August 6, 2019

**RE: 21st Century Academy
4300 Cutler Ave NE
Temporary C.O. - Accepted
Engineer's Certification Date: 07/31/19
Engineer's Stamp Date: 04/10/18
Hydrology File: H17D115**

Classroom and Gymnasium
Addition for:
**21st Century
Public Academy**

GRADING PLAN

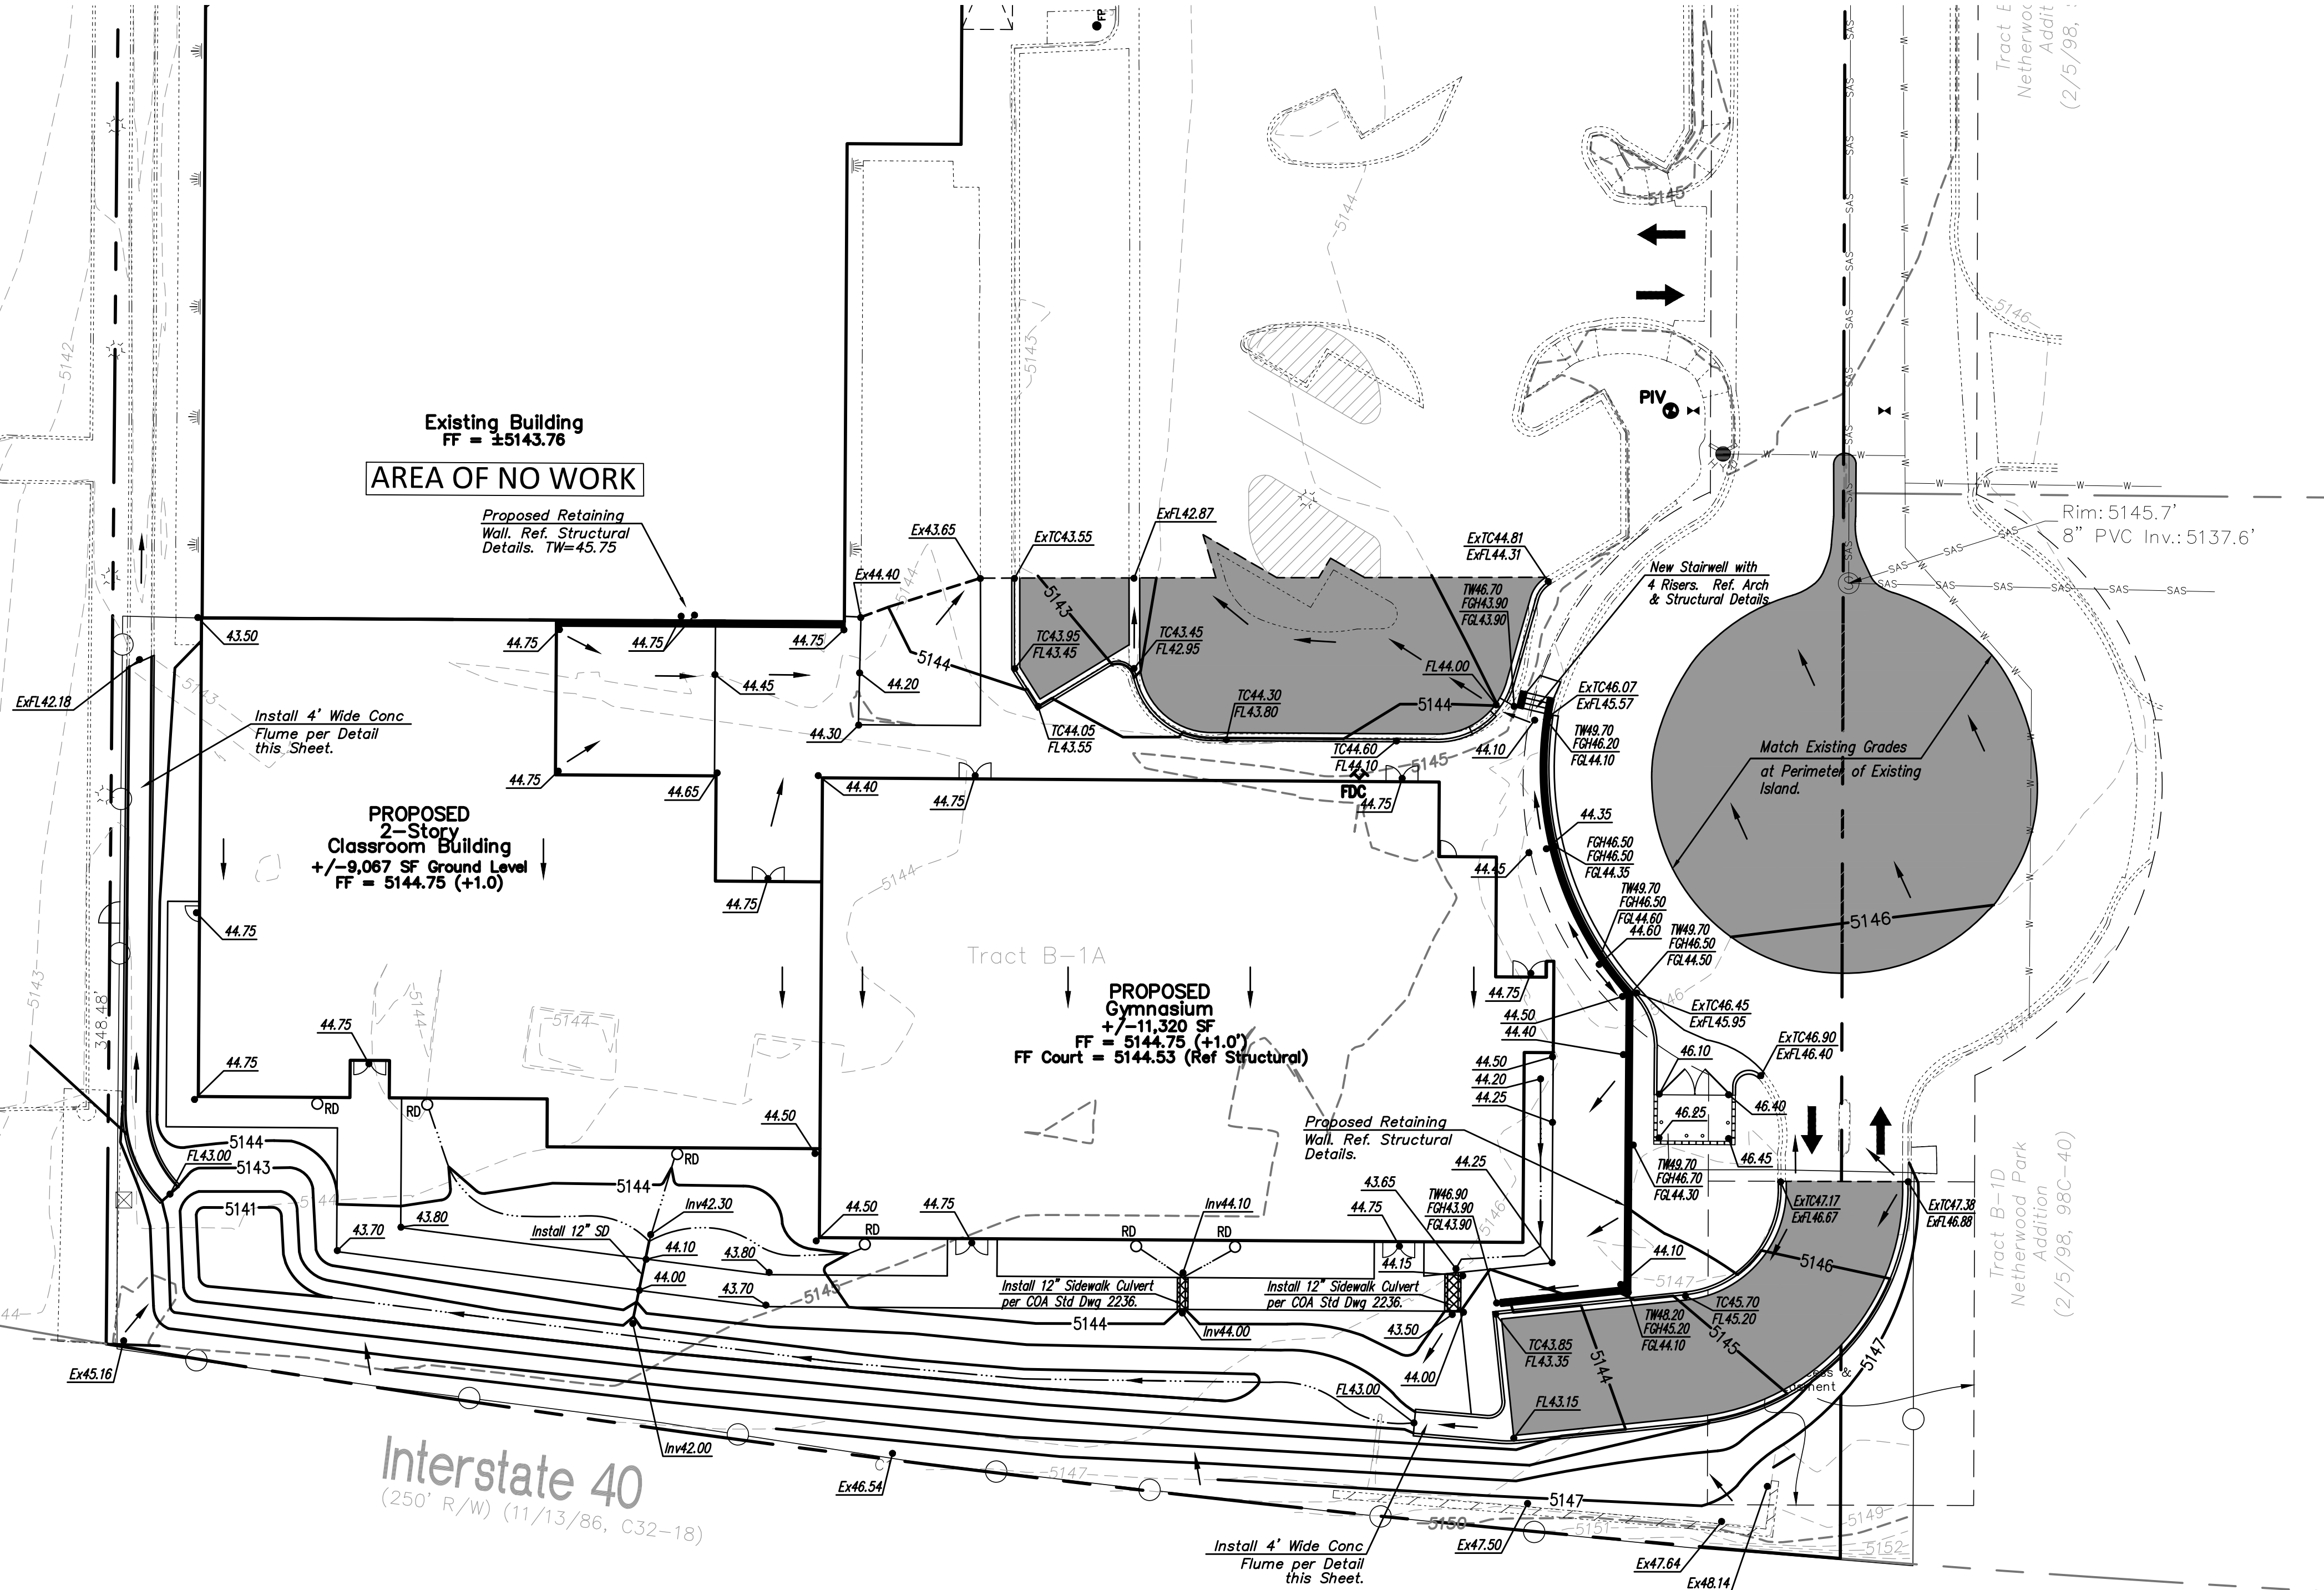
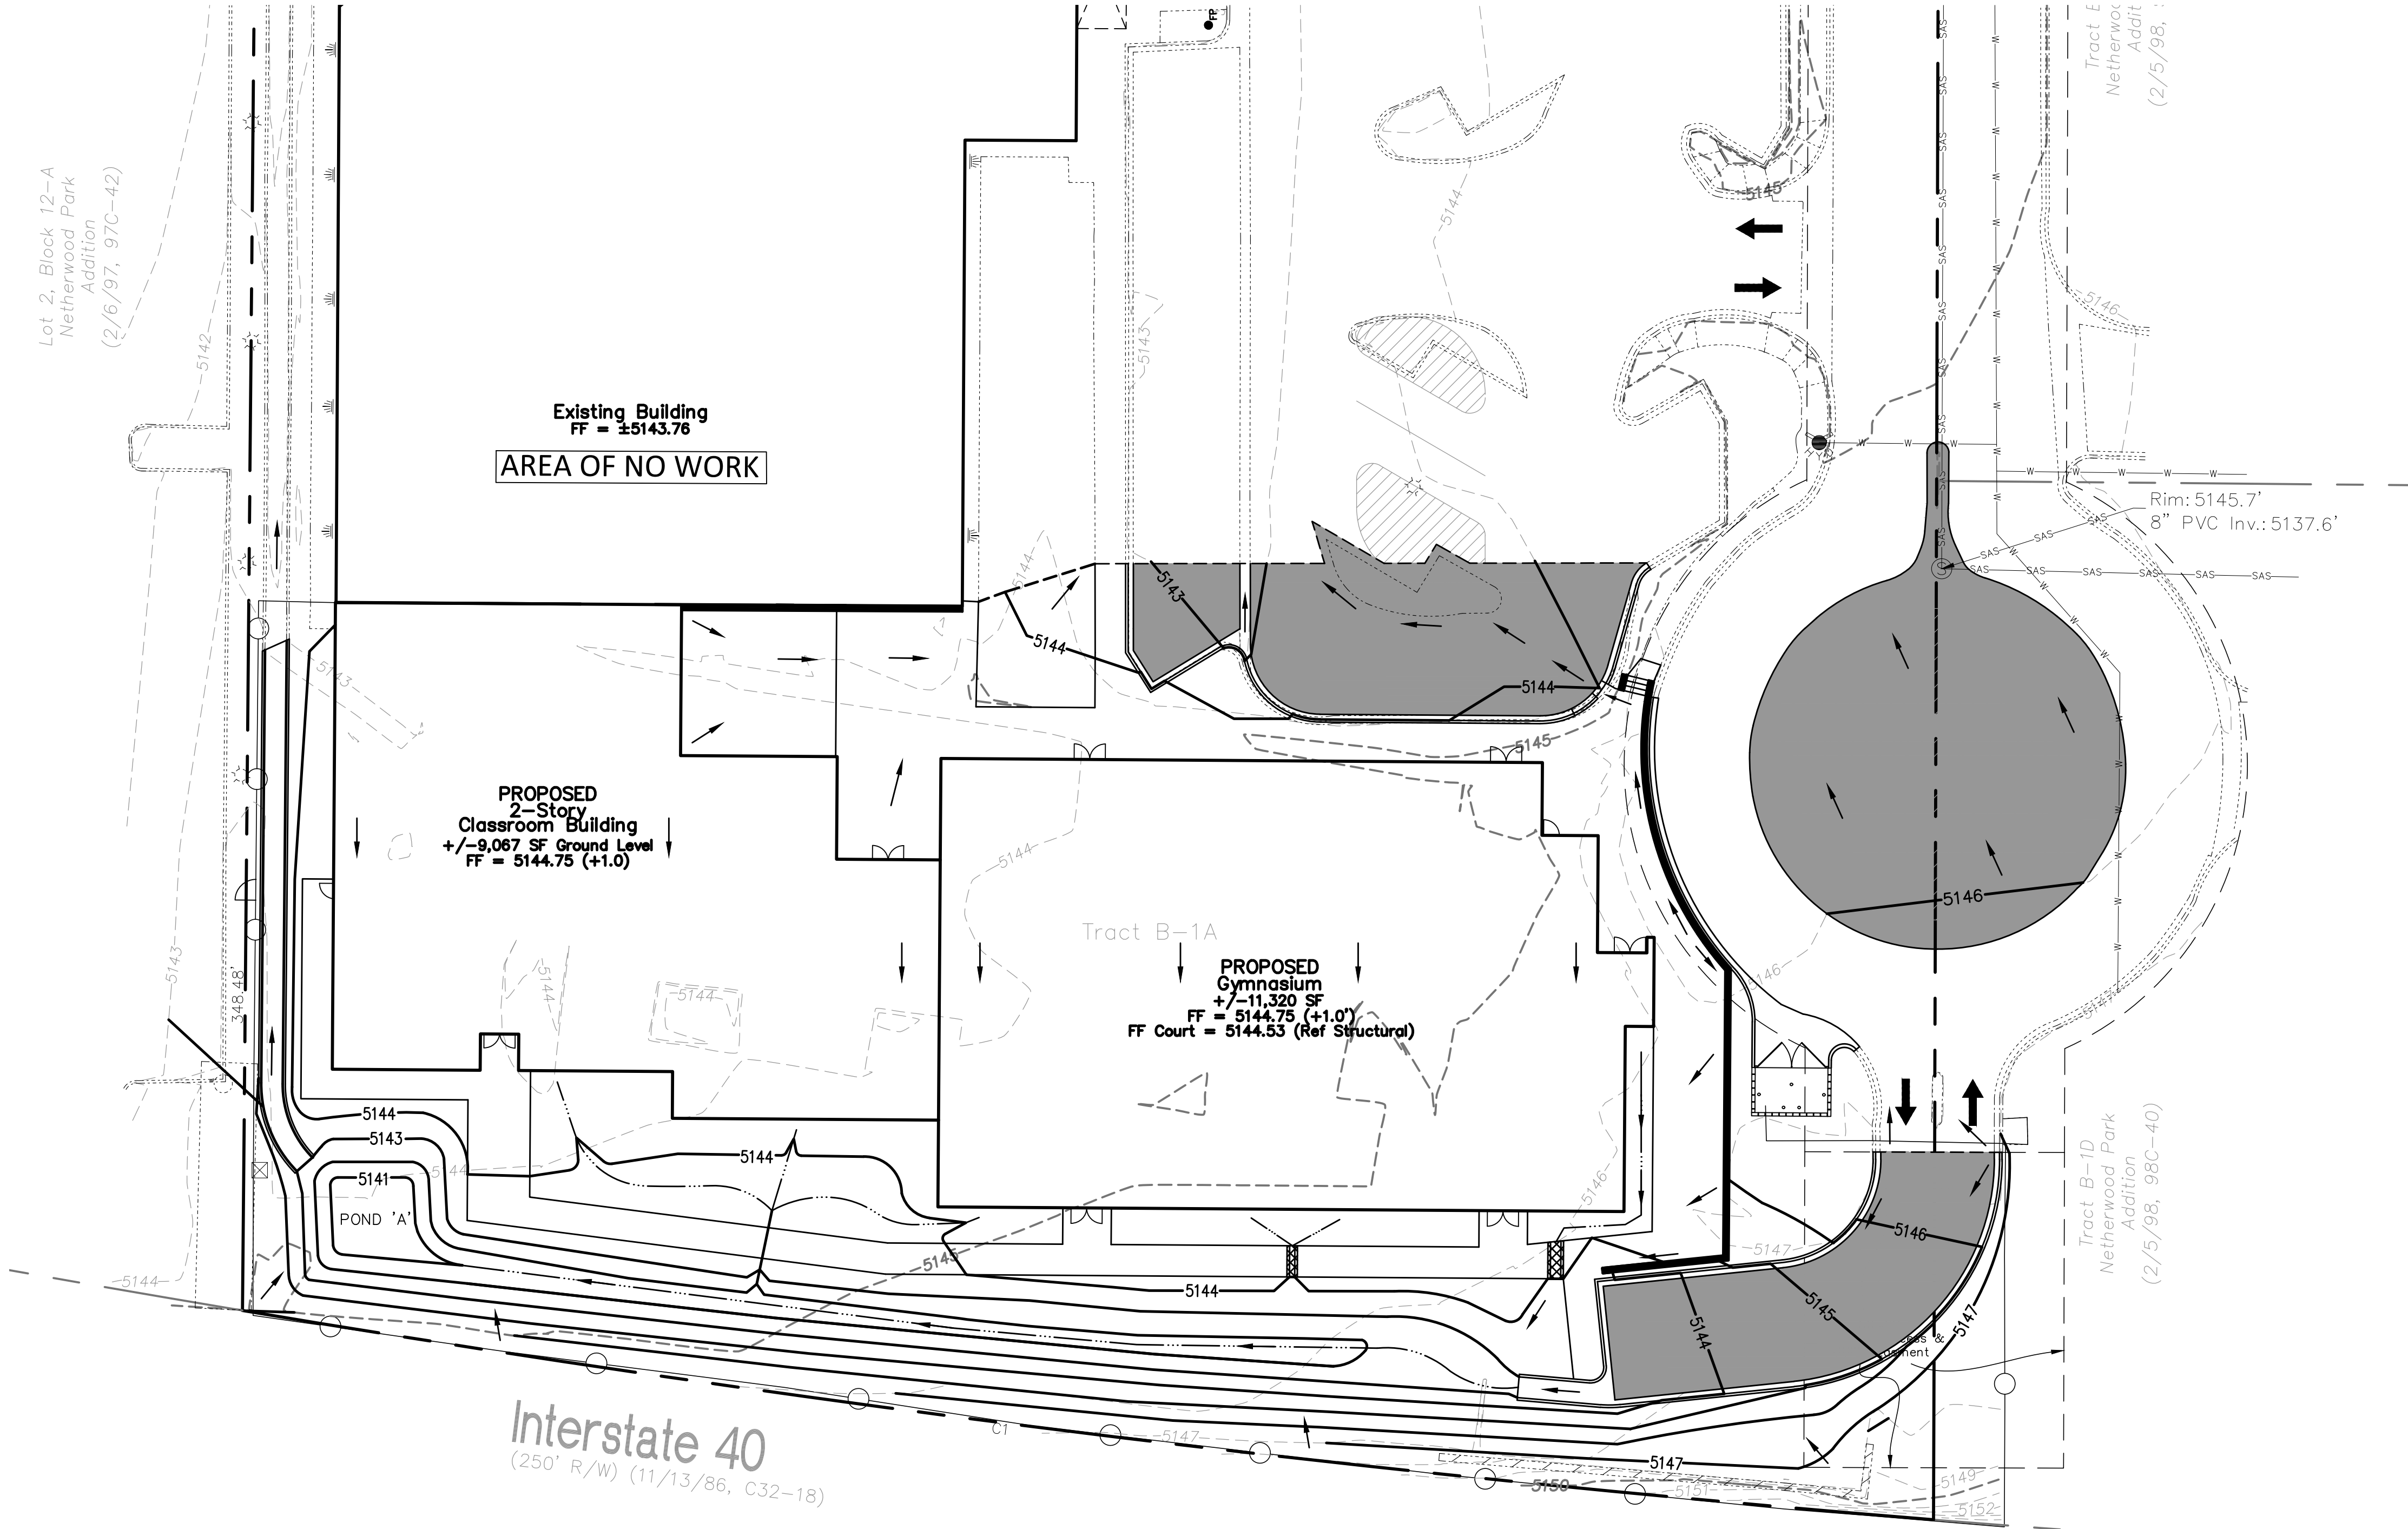
1. Please redline all the as-built conditions. For example, there were two sidewalk culverts on the approved G&D which was not installed. Instead plastic inlets under the roof drain and piped under the sidewalk to the swale/pond in the rear of the property. Also the approved G&D had swales from the western roof drains to the swale/pond. Again plastic inlets under the roof drain and piped under the sidewalk to the swale/pond was installed.
2. Please remove the dirt along the curb.

3. Please make sure that the plastic inlets have covers on them. There were a few that did not.

4. Please finish pond and swale gravel.
